From: Ray Grant <ray@northwoodgolf.co.uk>
Sent: 20 June 2024 11:48
To: Samuel Patten
Cc: Michael Briginshaw; Ian Johnston
Subject: RE: Further Information required for Northwood Golf Club details app
7932/APP/2024/1090
Attachments: Northwood Golf Club Spreadsheet.docx

Subject: RE: Further Information required for Northwood Golf Club details app 7932/APP/2024/1090

Appendix C
TREE FENCING DETAIL

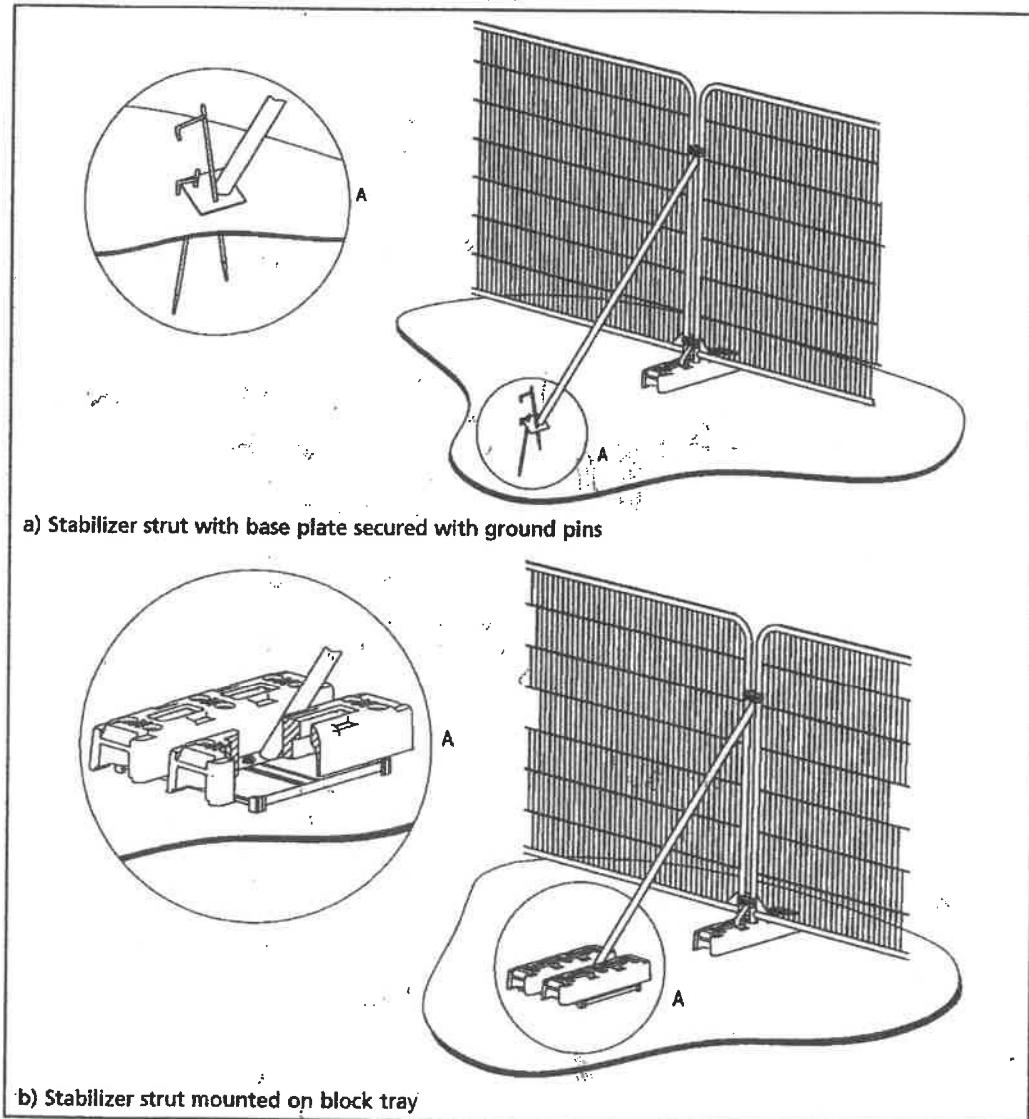
In terms of tree protection, we had concerns that the tree T1 highlighted below was located too close to the tree protection fencing. The plans should be amended so that the fencing is located as far away from the trunk as possible.

Please revise the protection fence plan to ensure it is shown outside the canopy edge of all trees. There is one tree where it is shown very close to the trunk.

With regard to tree protection we would confirm that Boundary fencing around the project will not adversely impact any of the existing trees. There is sufficient space for this not to be an issue.
